Your ref:  
Our ref: 23/00037/F  
Please ask for: Luke Swales  
Direct dial: 01553 616865  
E-mail: borough.planning@west-norfolk.gov.uk

Details: **Proposed new roof to create second floor accommodation along with rear dormer window and associated works at Himley House 47 Hythe Road Methwold Thetford Norfolk**

I have received a planning application as detailed above but cannot process it until I receive some more information:

P - 6673 - 01

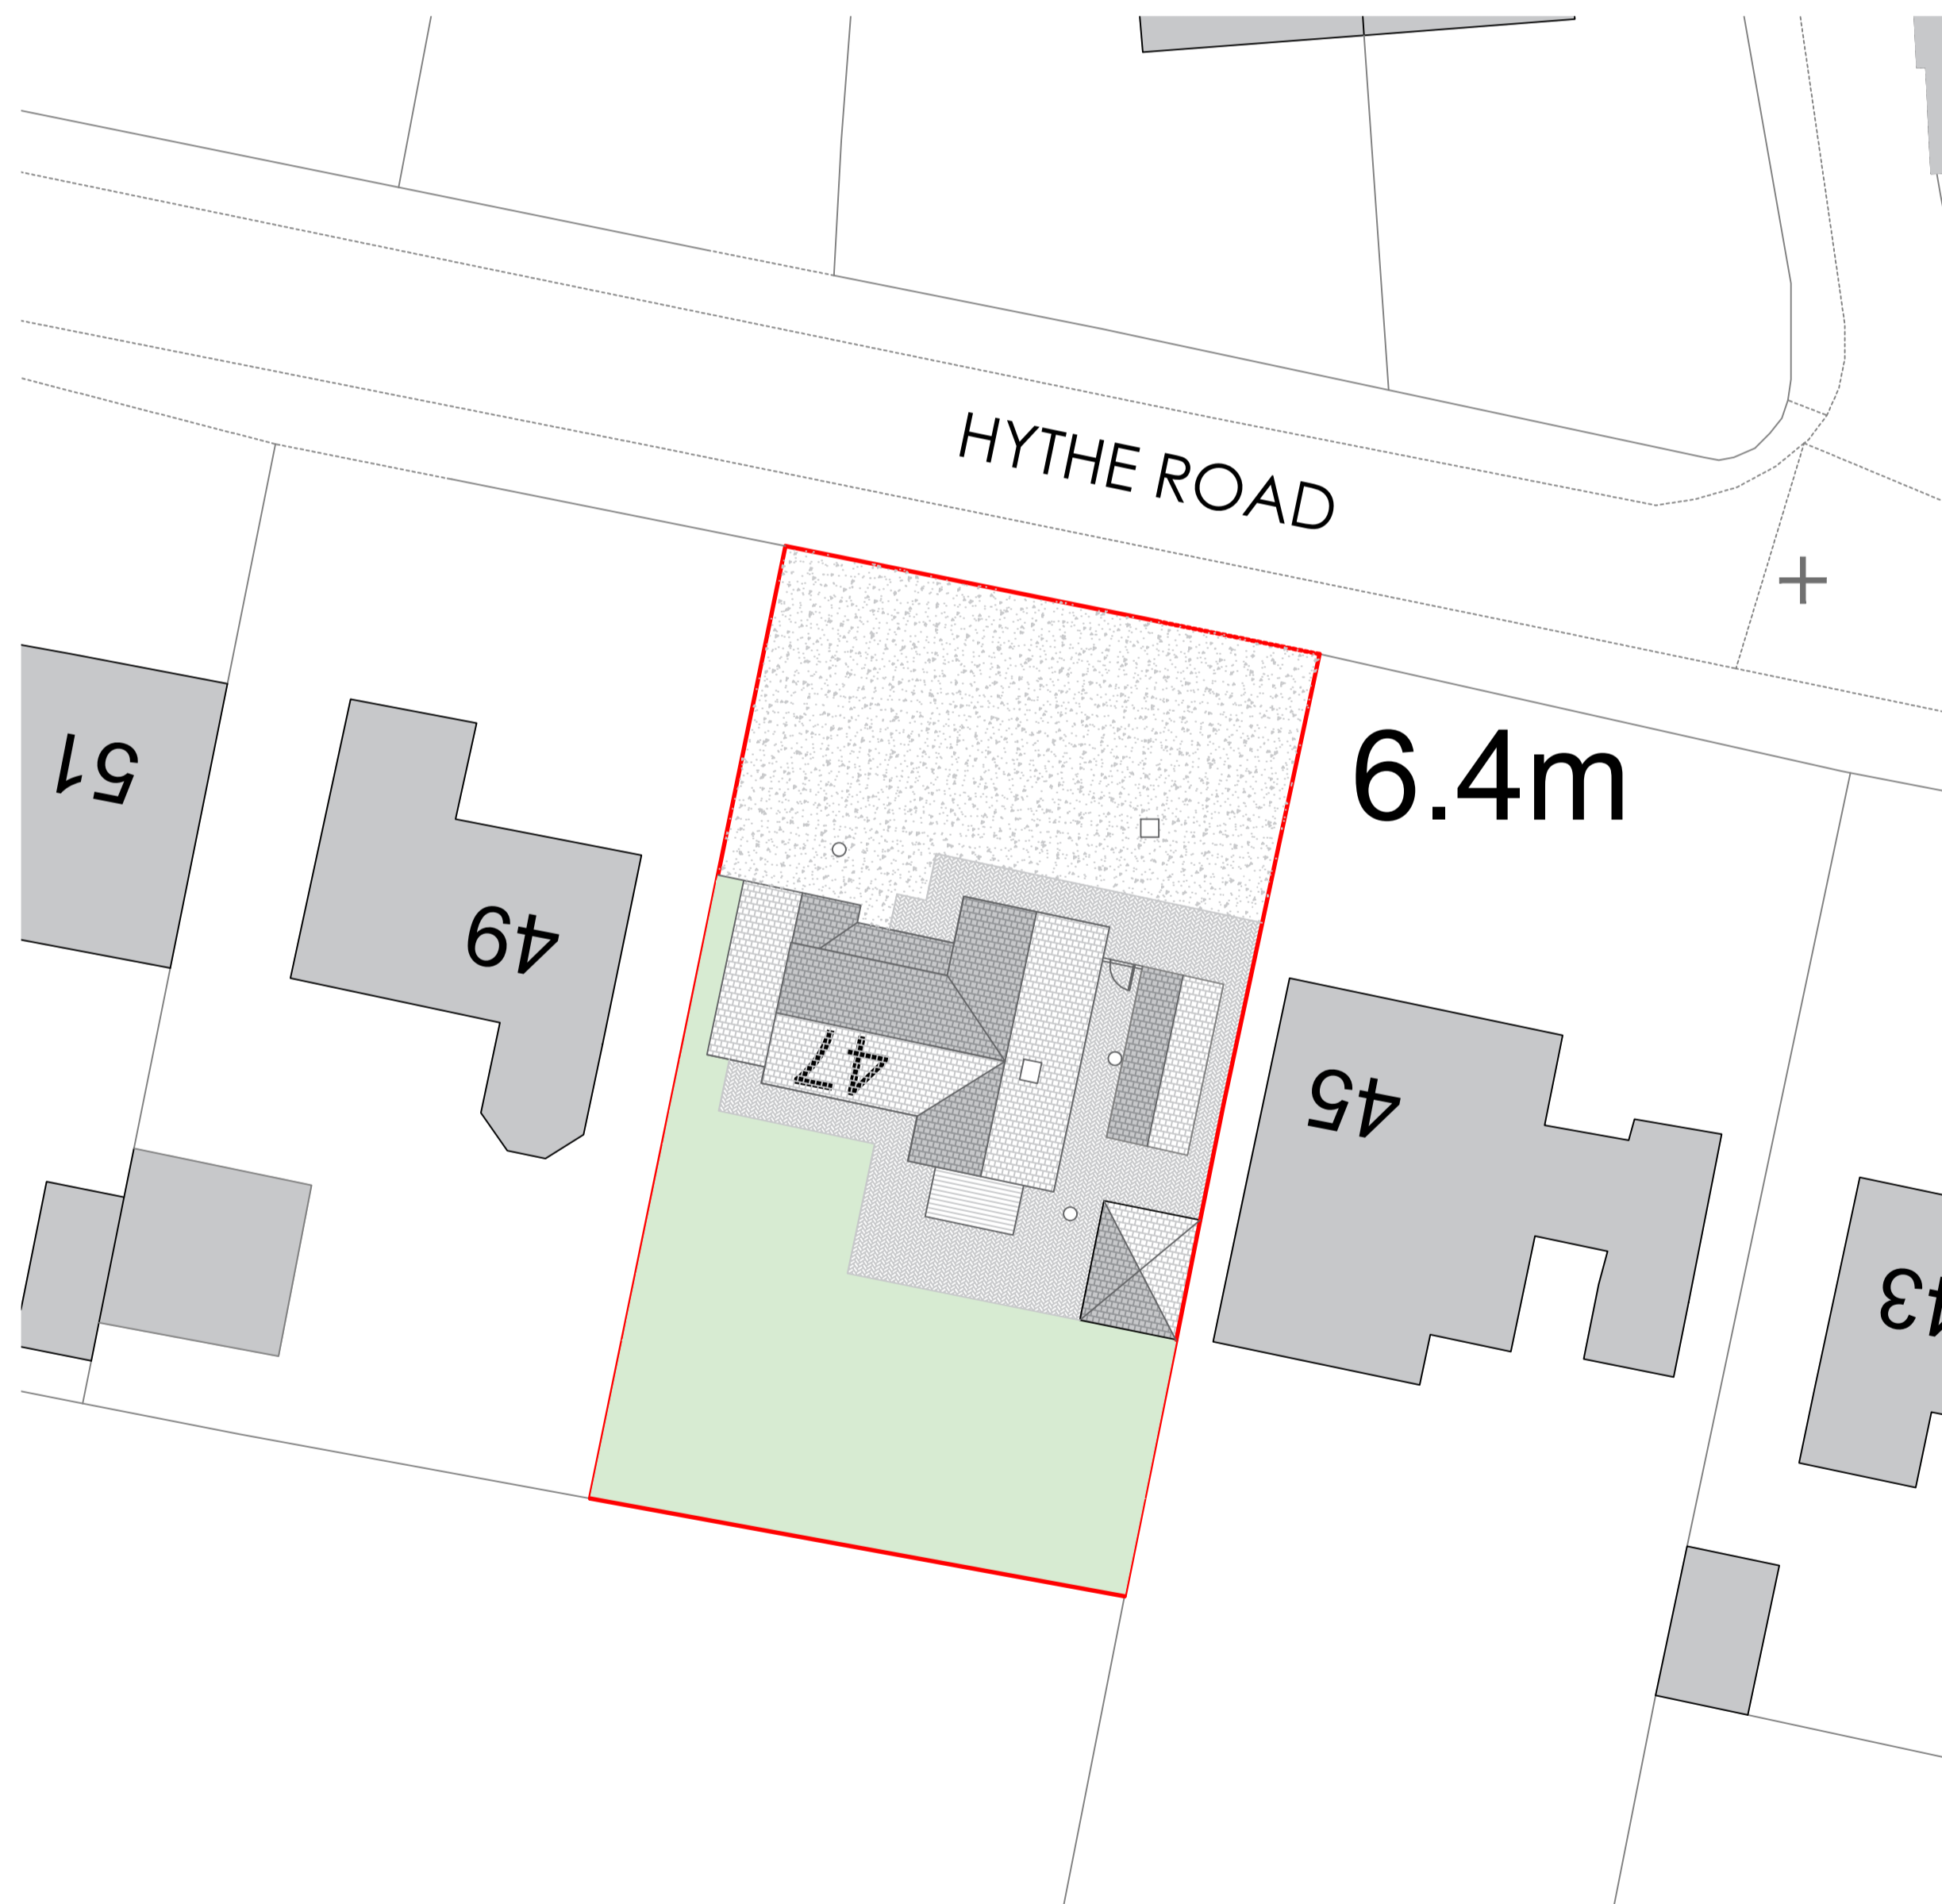
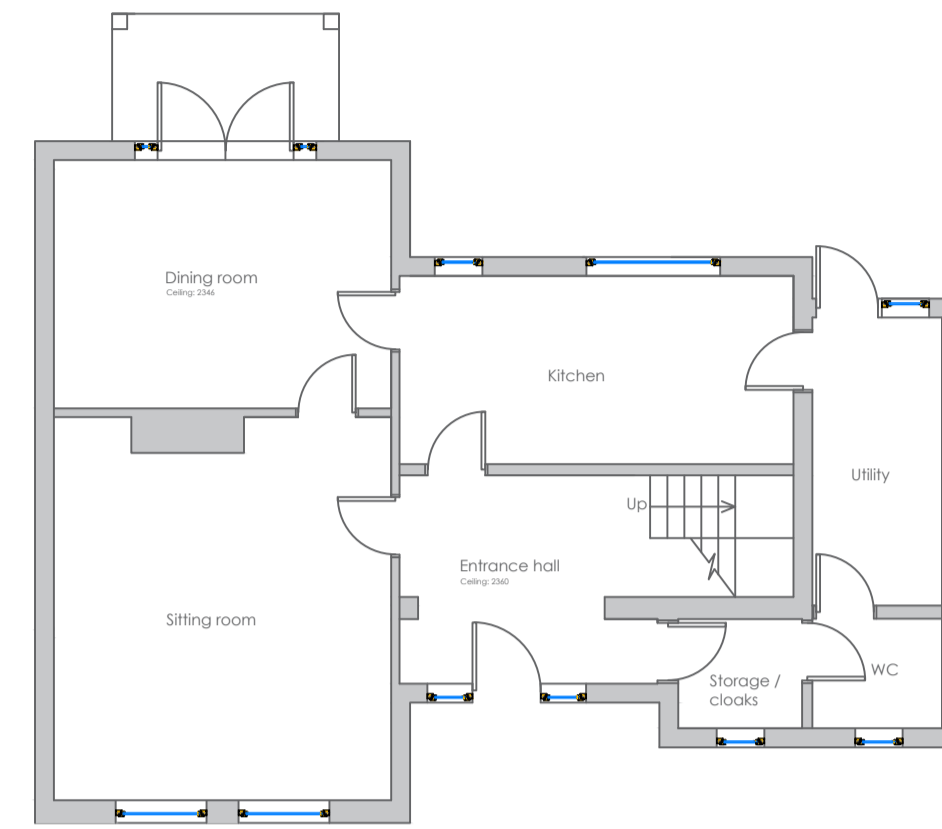
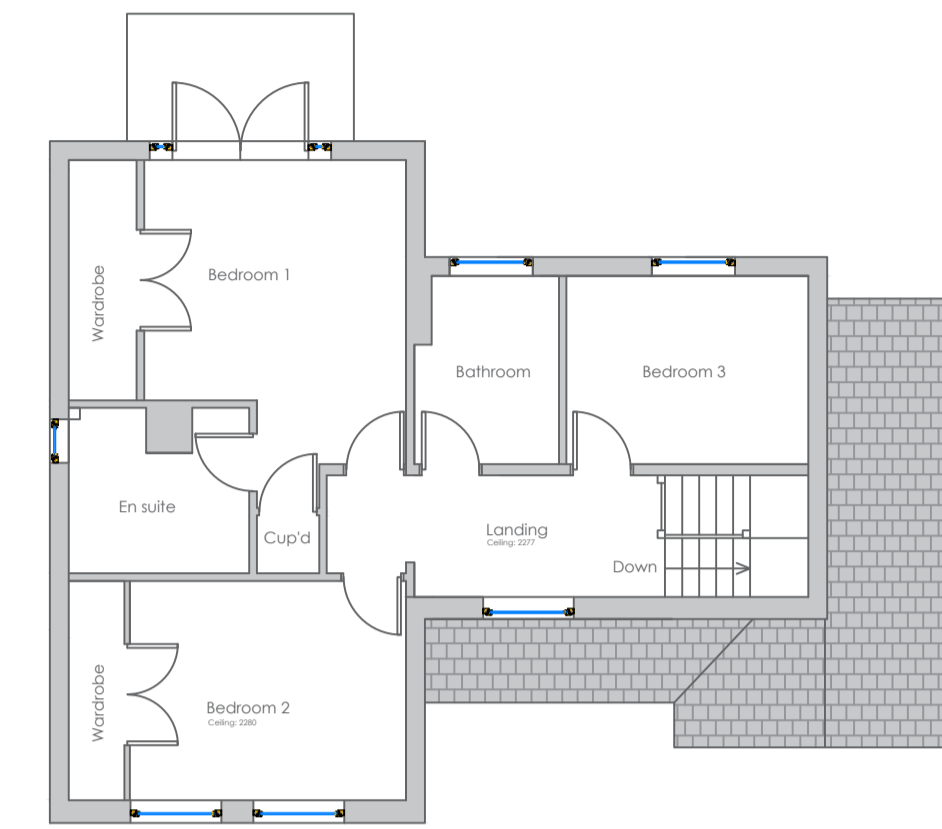
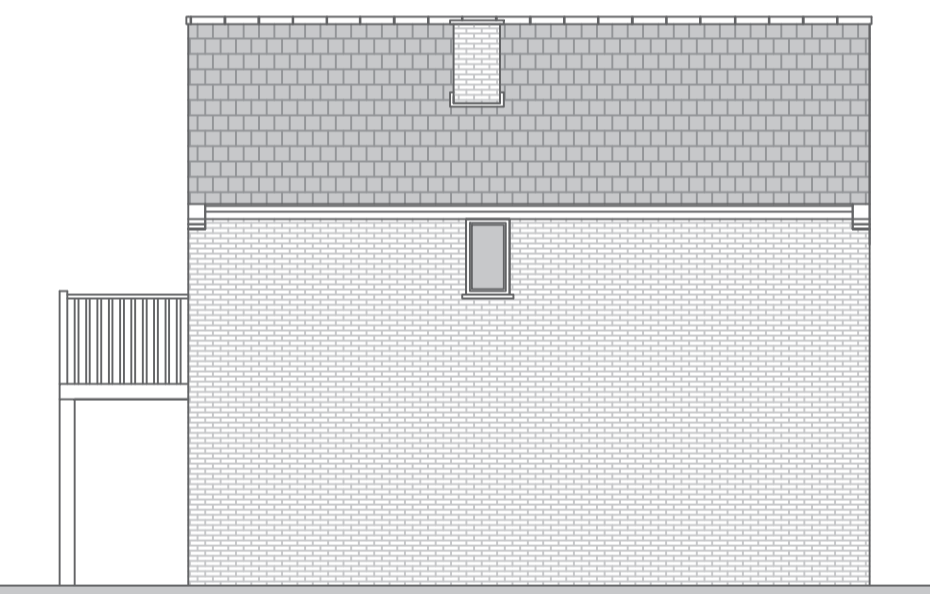
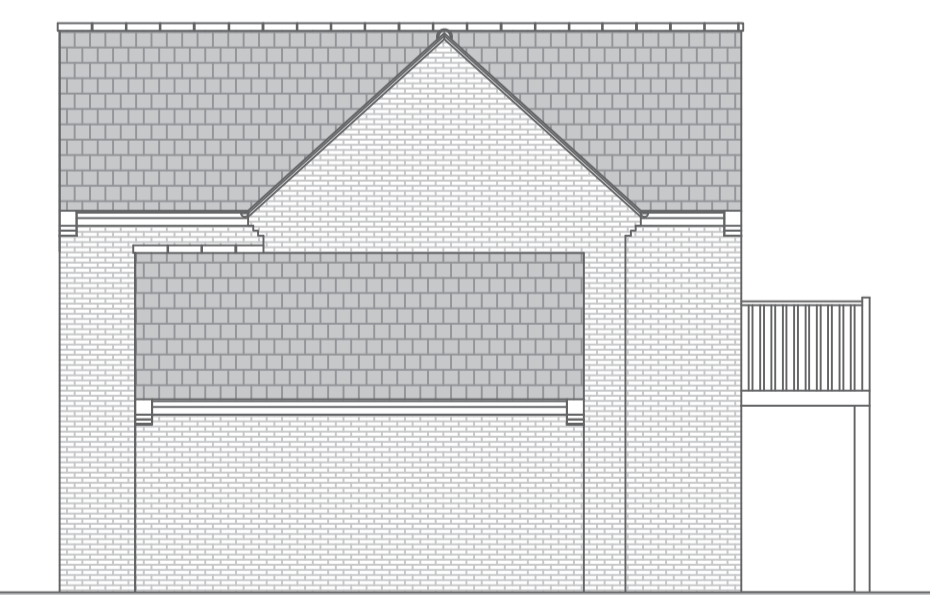
1. Please provide four copies of a drawing, to a recognisable scale, showing a section through the new extension.
2. In accordance with the National Validation Checklist, which became mandatory on 6 May 2008, we will require information regarding site levels. If site levels are to change, please provide four copies of a site survey drawing, alternatively, if site levels are to remain unchanged, this can be annotated on the relevant plan or advised in writing.
3. In the drawing notes it states "This drawing must not be scaled". Please remove this as all drawings must be true to their stated scales.
